From: Anita Gardner
Sent: 26 April 2012 10:18
To: Planning.Responses
Subject: FW: The Old Barn - Ferring - Application No. FG/6/12 & FG/4/12/L

RE: The Old Barn - Ferring - Application No. FG/6/12 & FG/4/12/L

Further to yesterday's telephone discussion, please find attachments with Febo Designs revised drawings No's 3214-006 rev C, 3214-009 Rev E, 3214-010 Rev E and 3214-011 Rev D.

DRAWING NO.	DESIGN	SCALE	DATE	REV.
3214-011	AF	1:50 A1	April/12	D

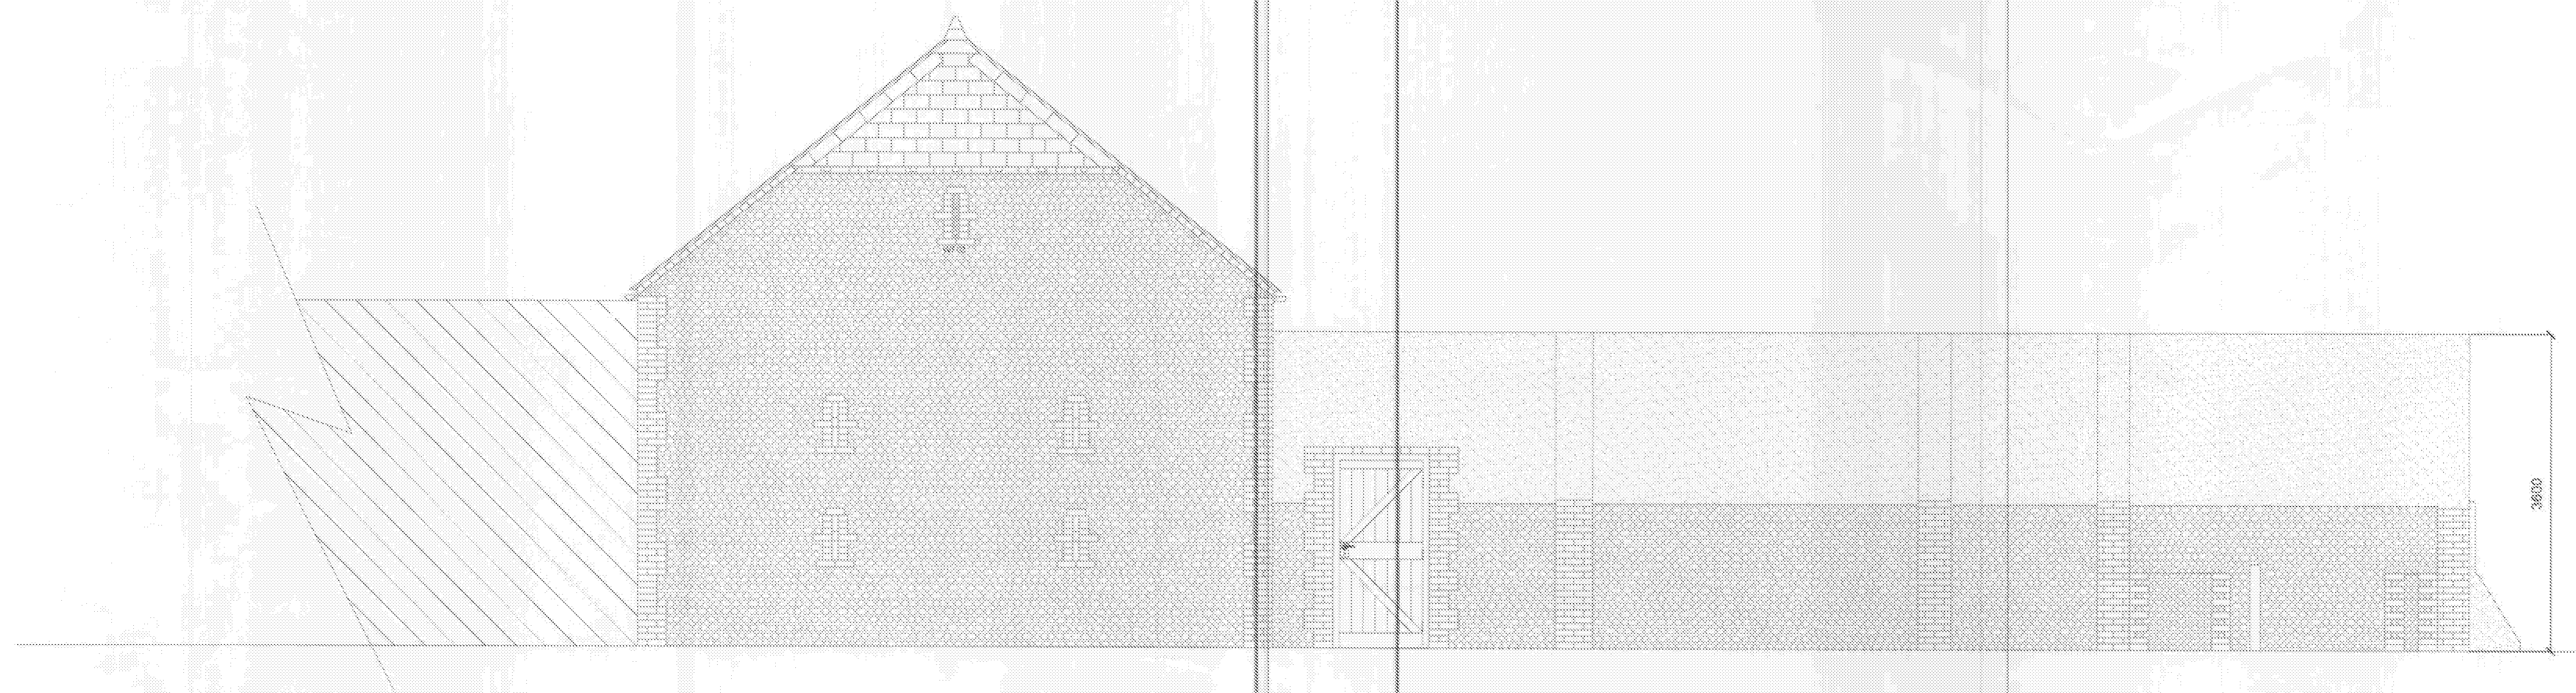
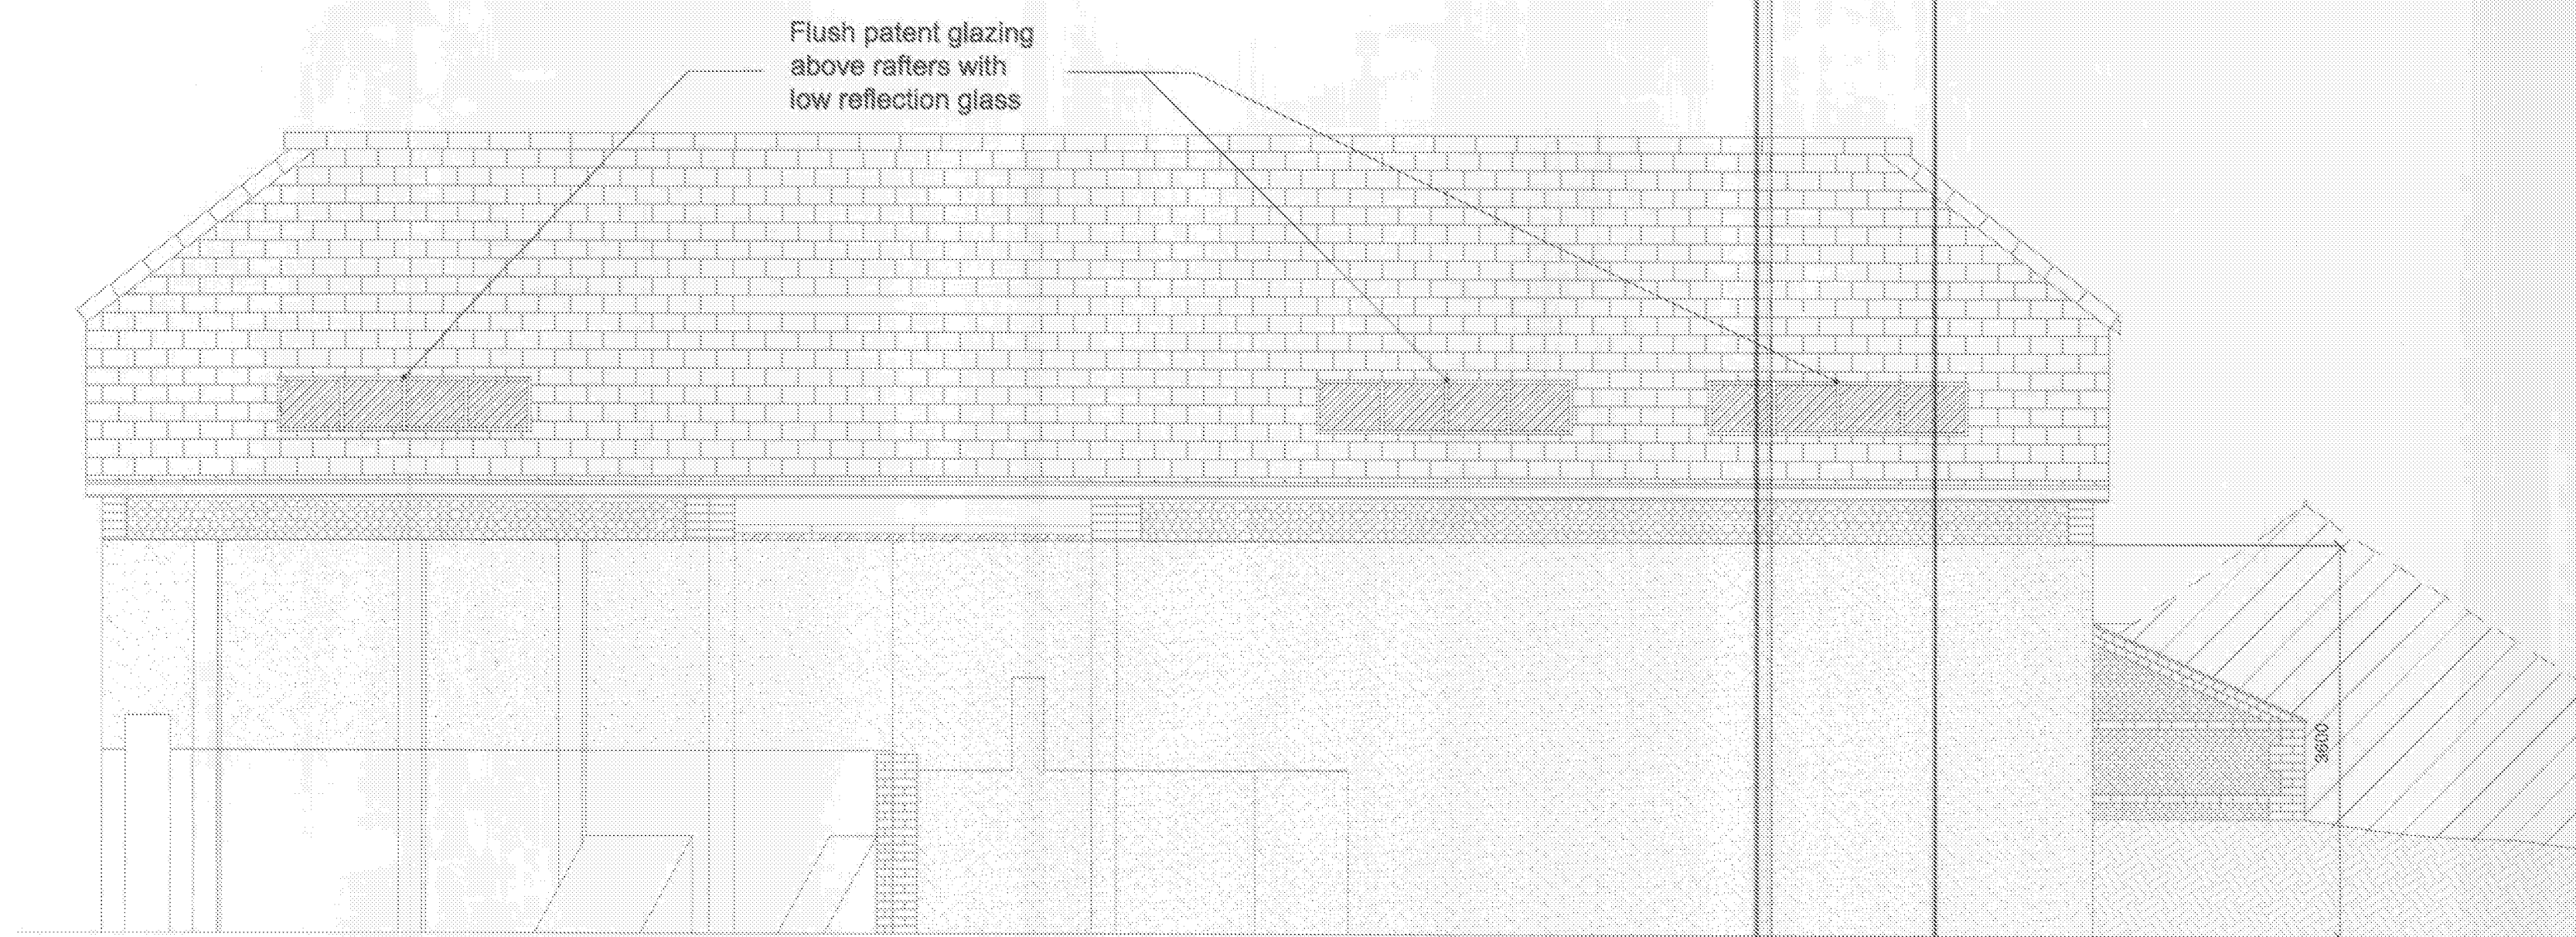
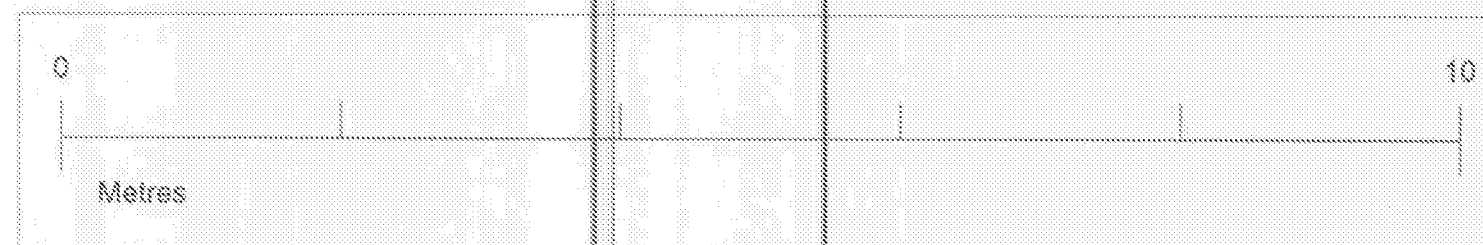
1. The Patent Glazing over the west entrance has been removed
2. The internal glazing to Bedroom 2 has been extended
3. The Study's partitions have been changed from solid to glazed construction
